APPENDIX 1.1
KILDARE COUNTY COUNCIL REQUEST FOR FURTHER INFORMATION

Date: 04/10/2024
Pl. Ref: 24/60787

Re: Planning Reference: 24/ 60787 - Herbata Limited - PERMISSION for a Data Centre and will comprise of: The demolition of 3 no. dwelling houses, associated garages and farm outbuildings / agricultural buildings (total floor area 1,591m²); The construction of 6 no. two storey data centre buildings, each with loading bays, external plant area including electrical and mechanical plant rooms, fuel compound, sprinkler tanks and associated ancillary development; Data centre building Nos. 1, 2, 3, 4 and 6 will consist of: a data hall (24,756m², overall height 19m), an administration block (2,505m² overall height 15m) and include an external screened plant area of 18m in height and 6,164m²; Gas turbines, gas engine and battery energy storage systems will be provided within each plant area; Data centre building No. 5 will consist of: a data hall (24,756m², overall height 19m), an administration block (2,505m² overall height 15m) and include an external screened plant area of 18m in height and 6,375m² in area and includes infrastructure for district heating; Gas turbines, gas engine and

Rev.	Date	Description
P08	28/04/2024	ISSUED FOR PLANNING
P07	03/11/2023	ISSUED FOR PLANNING
P06	07/09/2023	ISSUED FOR PLANNING
P05	06/08/2023	ISSUED FOR PLANNING
P04	12/07/2023	ISSUED FOR INFORMATION
P03	10/07/2023	PROGRESS ISSUE
P02	30/06/2023	PROGRESS ISSUE
P01	06/06/2023	PROGRESS ISSUE

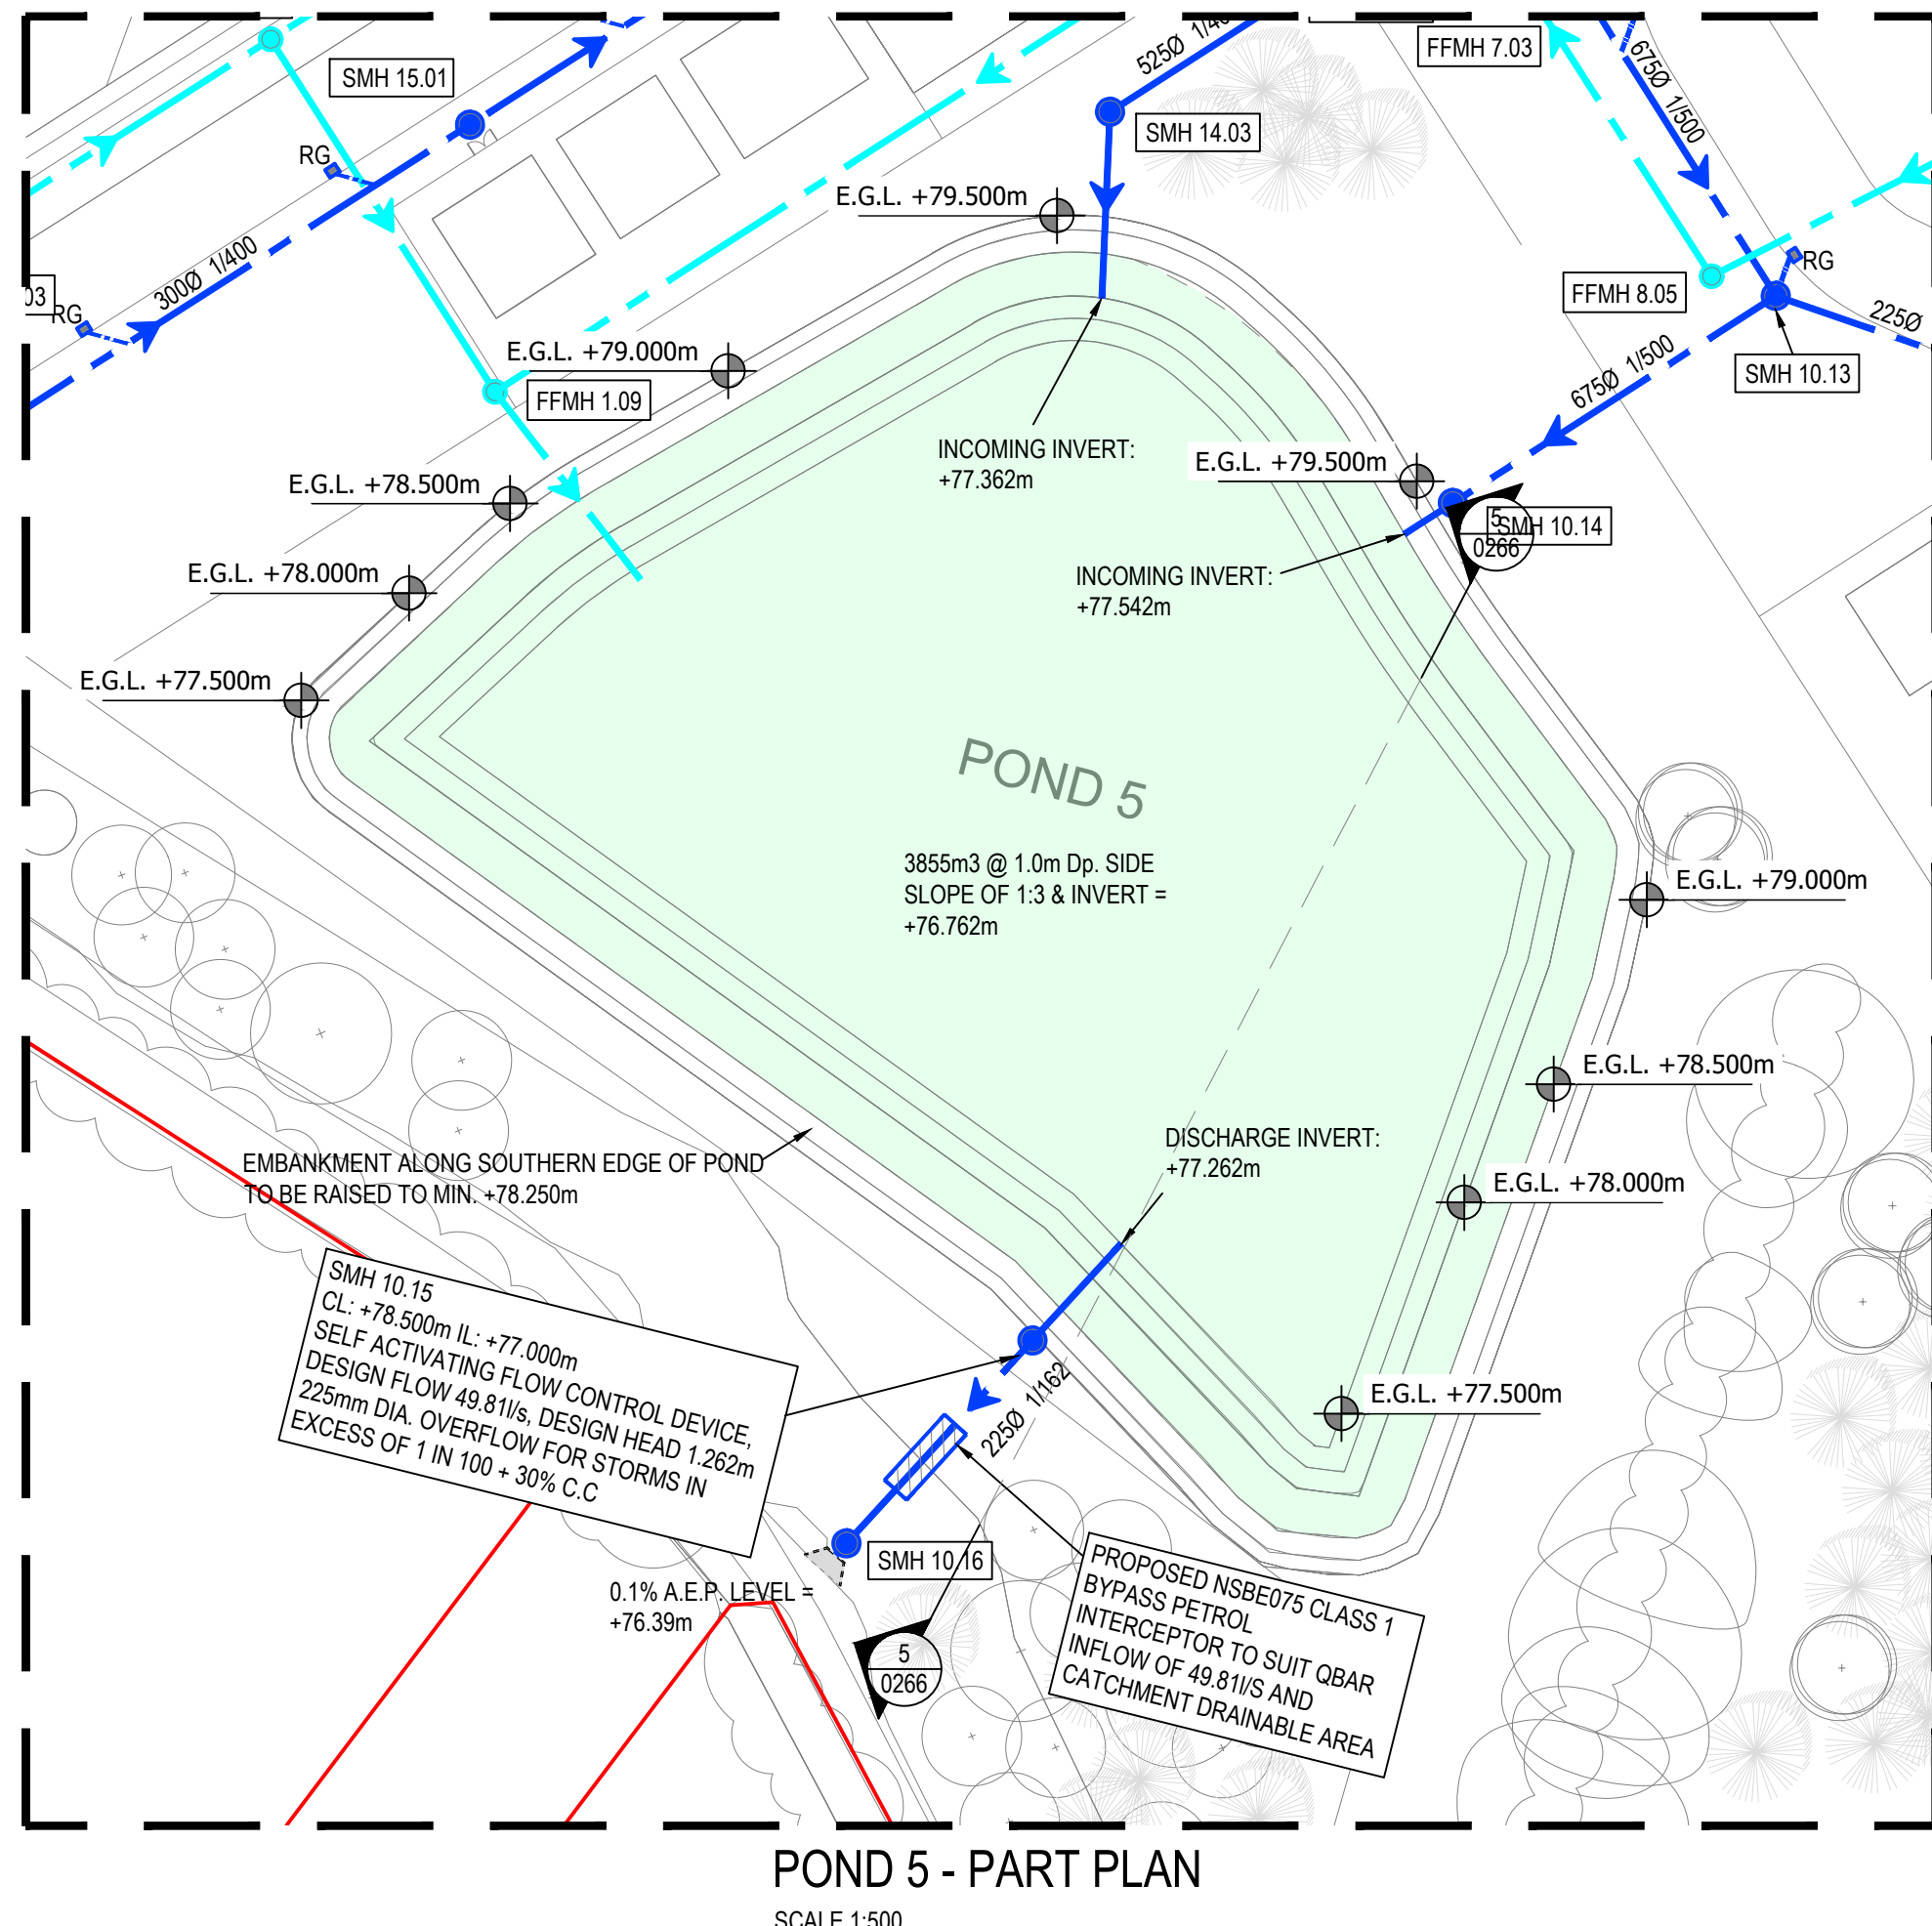
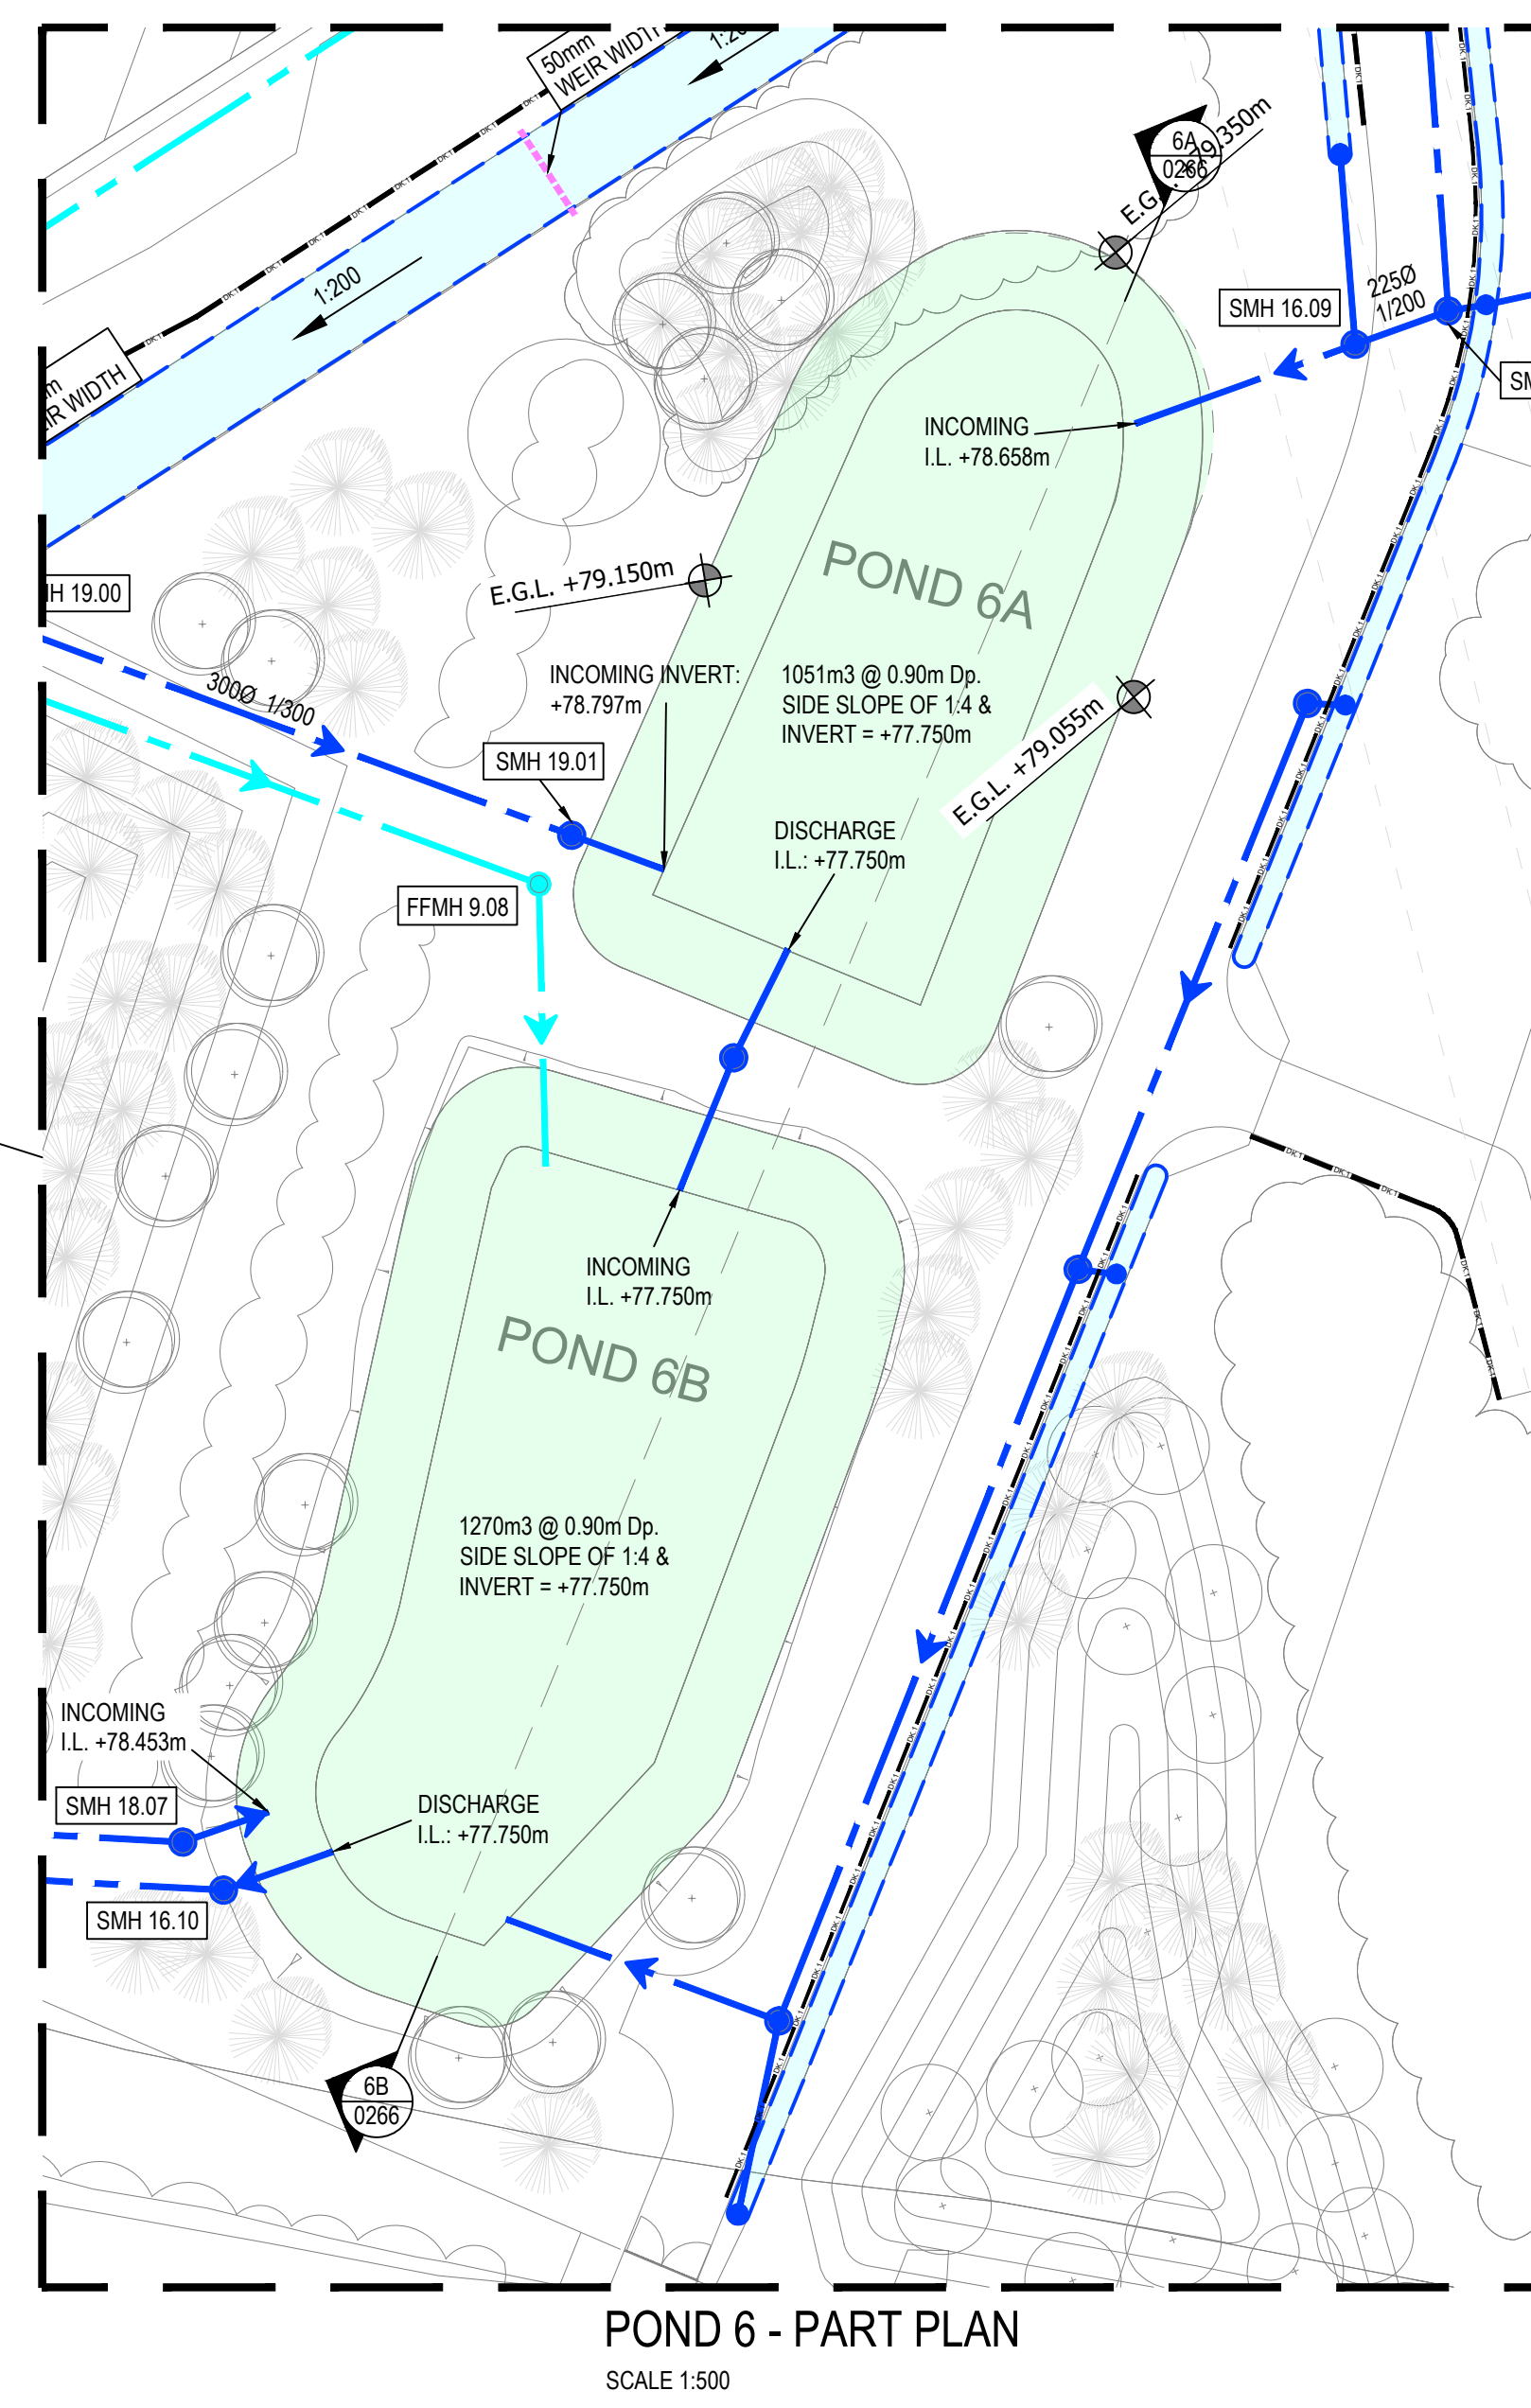
26. There is a query in relation to the figures pertaining to the estimation of the greenfield runoff rate at 6 l/s/ha. The Applicant is requested to reissue the design with a revised Qbar rate and confirm that the available attenuation storage for the site provided in the proposed ponds and basins on the site layout plan have sufficient capacity to store the increased water volumes associated with the reduced Qbar rates.

27. The Applicant is requested to reissue the Proposed SuDS Detail drawings highlighting the correct Qbar rate at each of the outfalls.
